CITY OF ALBUQUERQUE

September 16, 2014

**Re: Main Bank
Menaul/Prospect
Conceptual Grading & Drainage Plan (H19D055A)**

**CONCEPTUAL**

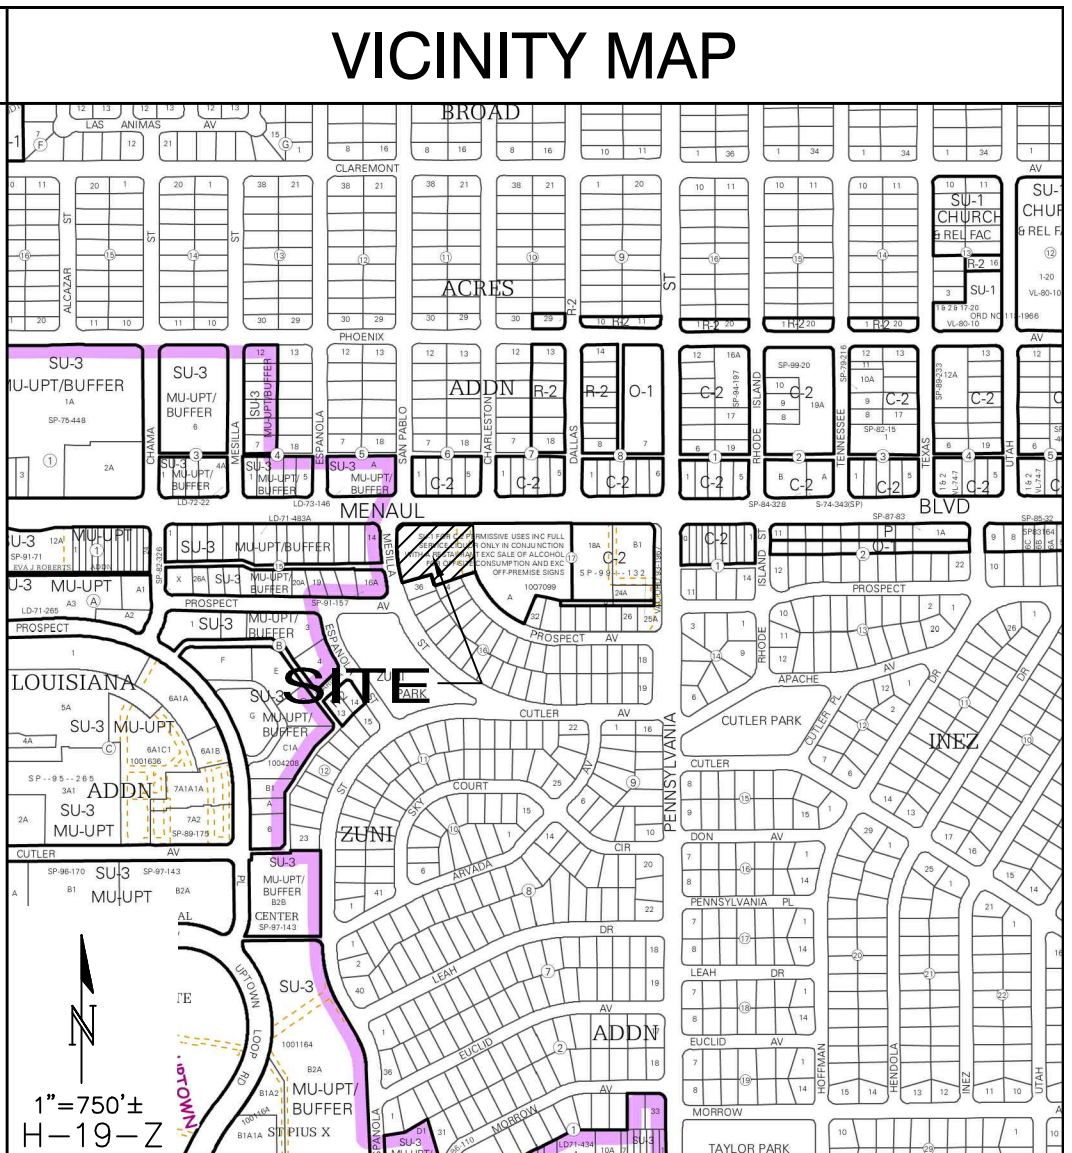
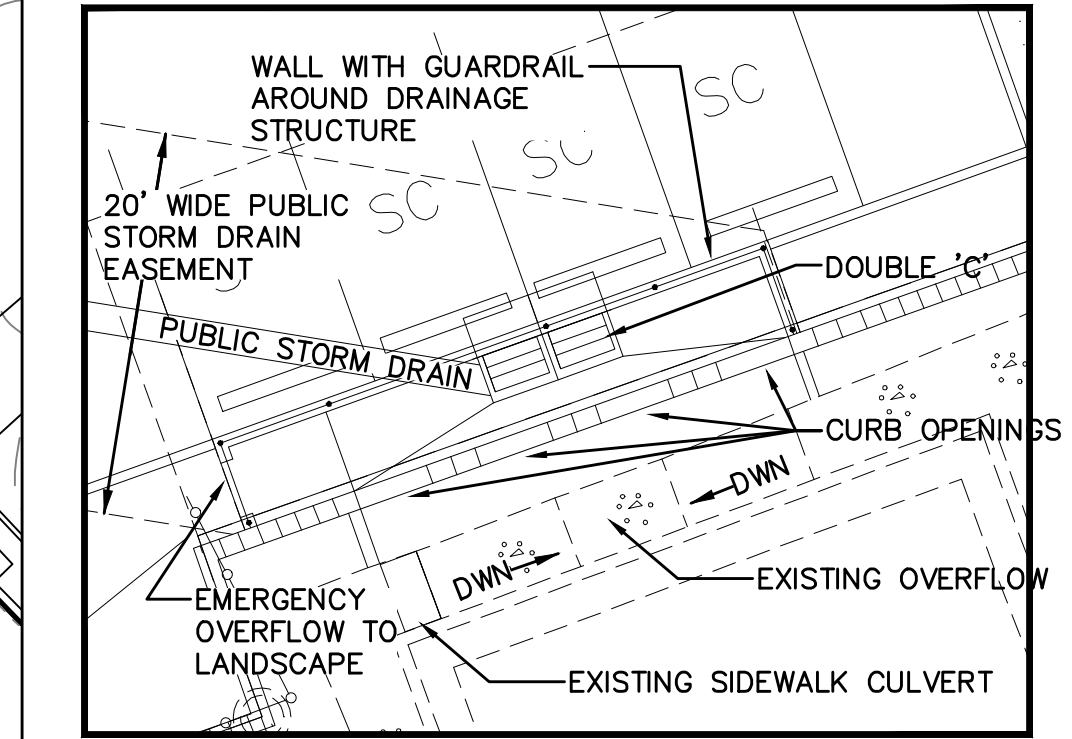
- Show the inlets and storm drain from Prospect Ave to Mesilla Ave.
- An emergency opening should be provided in the CMU wall at the end of Prospect Ave.

When submitting for building permit review, describe how the site will manage the first flush. Also, I noticed that curb openings are not shown in the landscaping for the first flush to enter or exit.
